REQUEST

Current Zoning: MX-1(INNOV) (Mixed-Use District, Innovative), N1-A (Neighborhood 1-A), and IC-1 (Institutional Campus-1)
Proposed Zoning: MX-1(INNOV) SPA (Mixed-Use District, Innovative, Site Plan Amendment) and N1-D(CD) (Neighborhood 1-D, Conditional)

Approximately 19.58 acres located west of Lawrence Orr Road, south of Johnnette Drive, east of W T Harris Boulevard, and north of Barcliff Drive.

The petition proposes to develop a vacant site with up to 96 single family detached and/or single family attached dwellings.

EXISTING
CONDITIONS AND
TECHNICAL DATA
SHEET

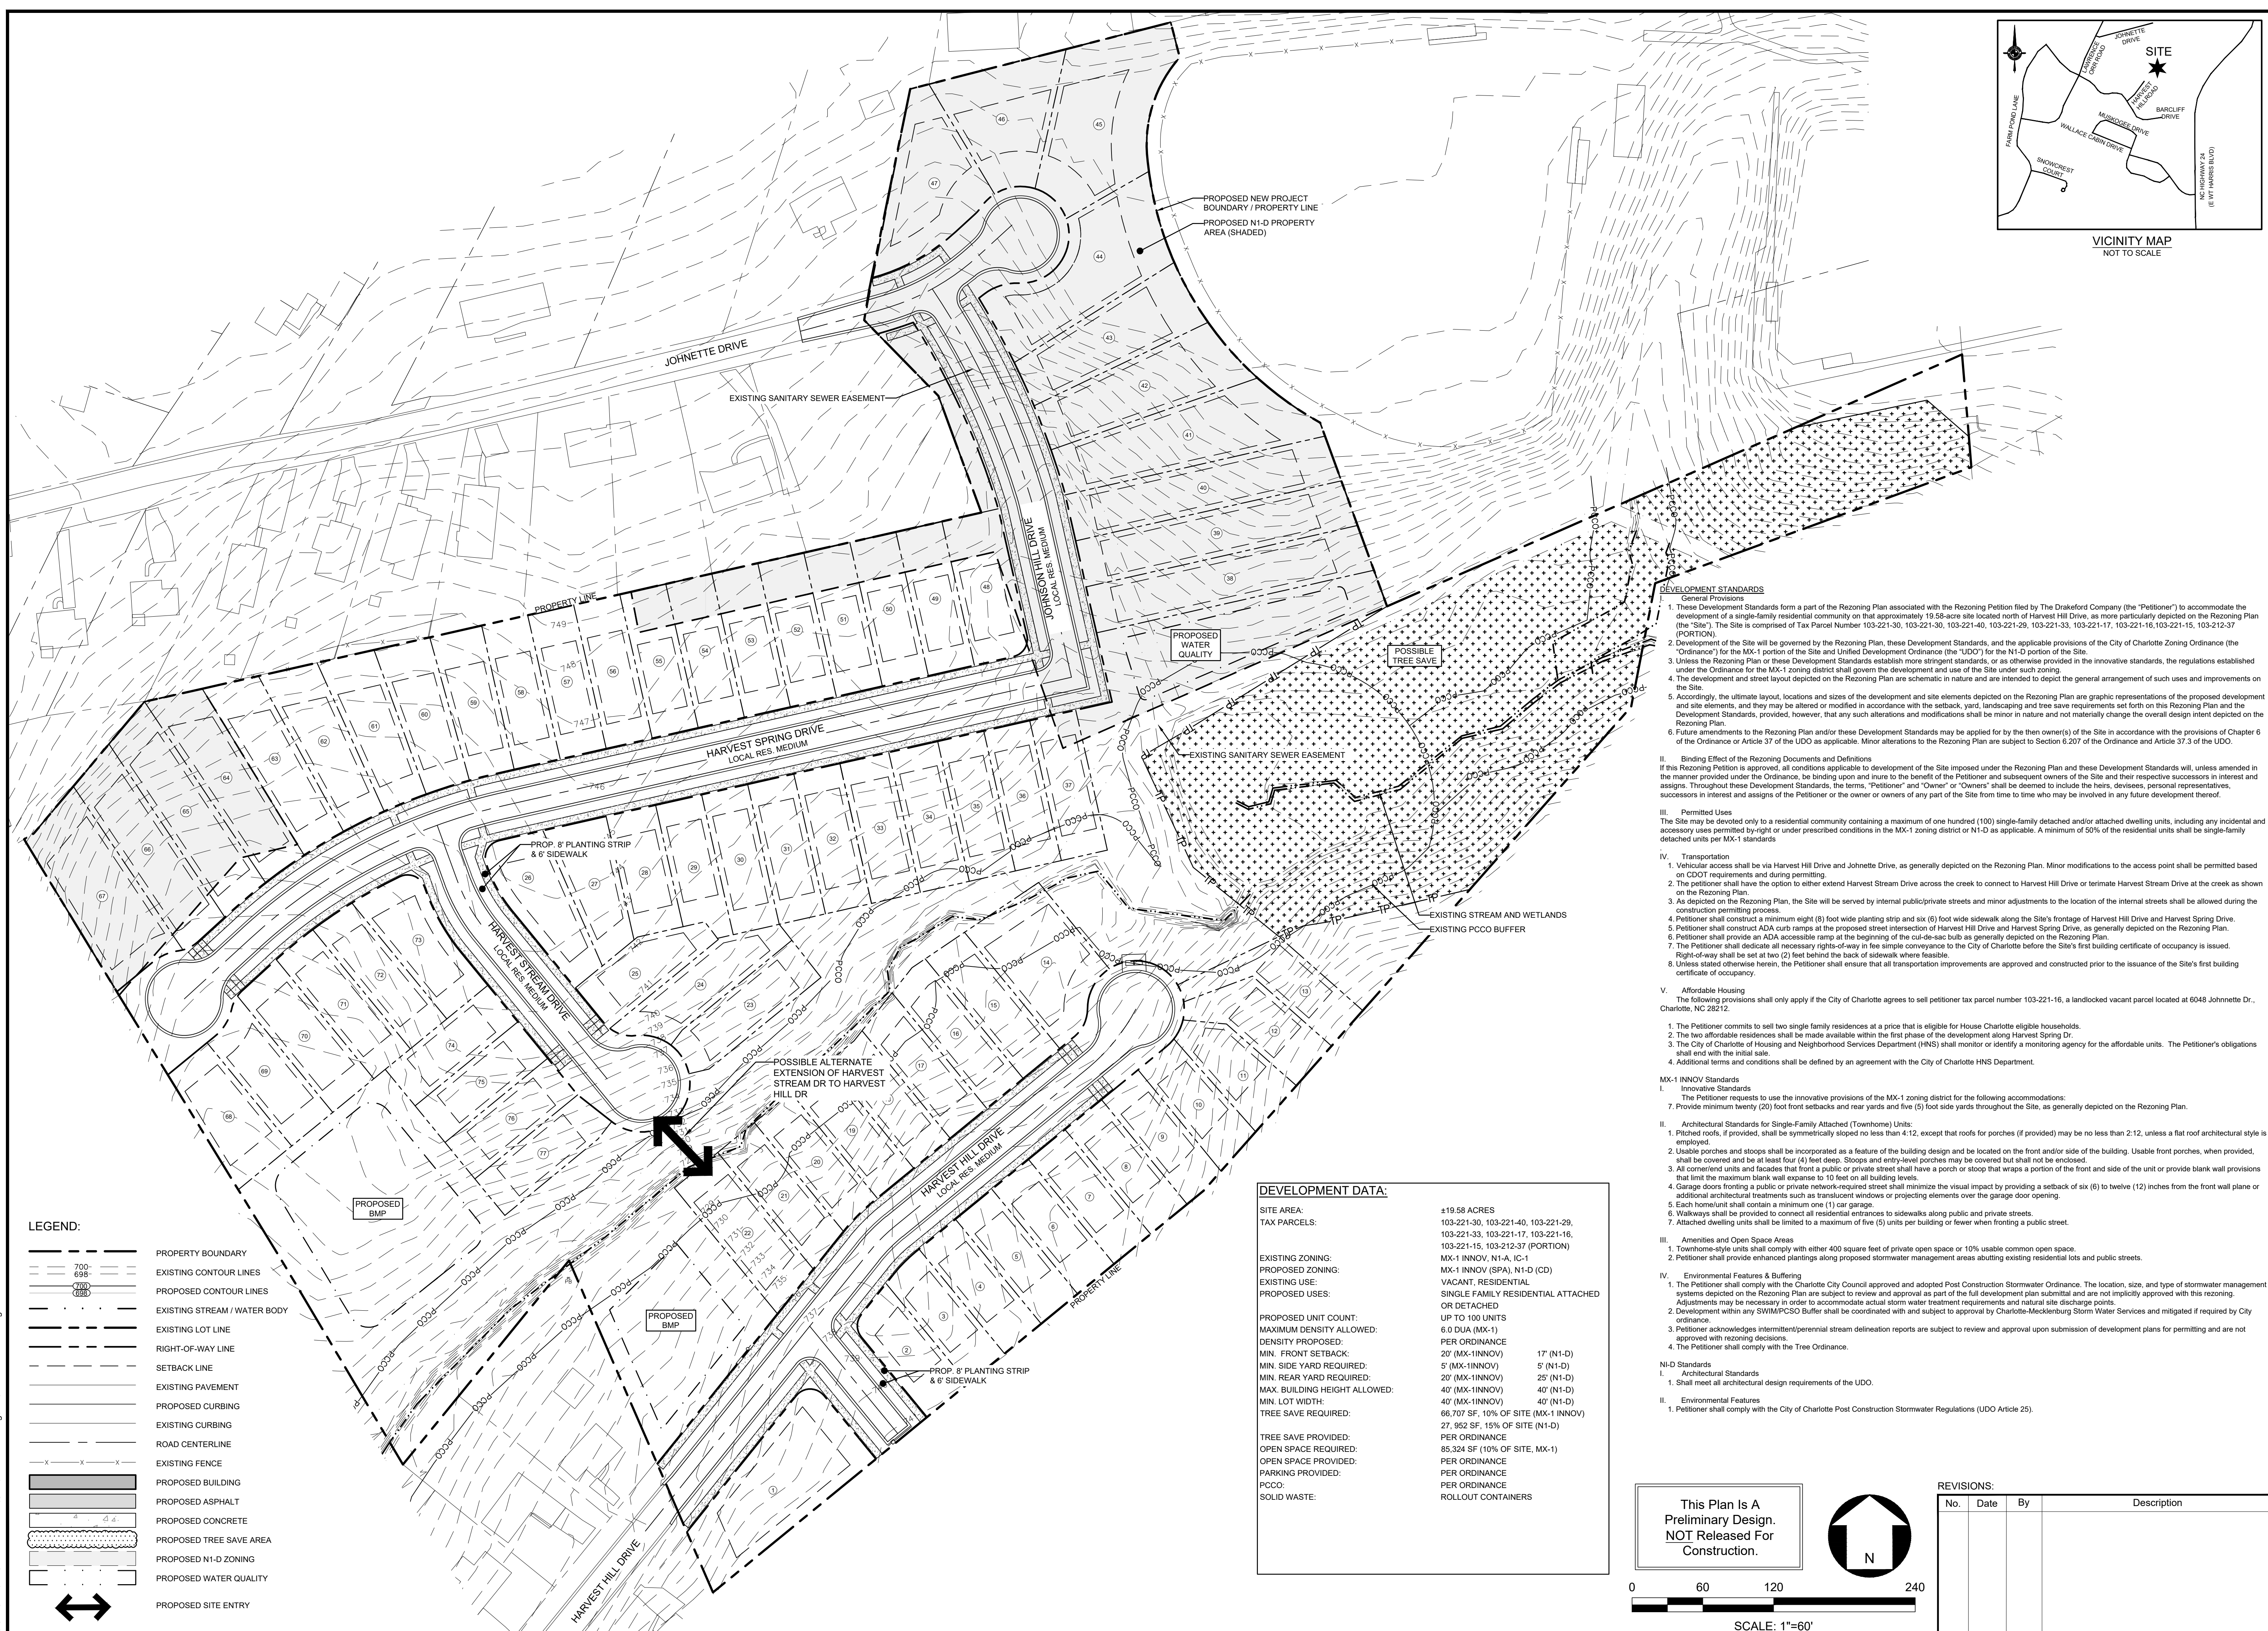
1. Provide a conditional note stating that the proposed lots on Johnnette Drive will be limited to single-family detached and/or duplex dwellings.
2. Revise conditional note V.2 to state "Two units for affordable home ownership to be provided along Harvest Spring Dr. Affordable units must reflect the design and character of the units constructed within the development. Affordable units to be substantially complete before the first certificate of occupancy is issued for the development. "

3. Revise conditional note IV-3 to include Harvest Stream Drive. All internal new roads and road extensions shown on the site plan should be listed.

4. Provide a tree survey identifying all city trees 8" DBH or greater and all planted city trees, all existing heritage trees, and any existing areas of the site used for credit toward meeting previously approved tree save or green area requirements.
-
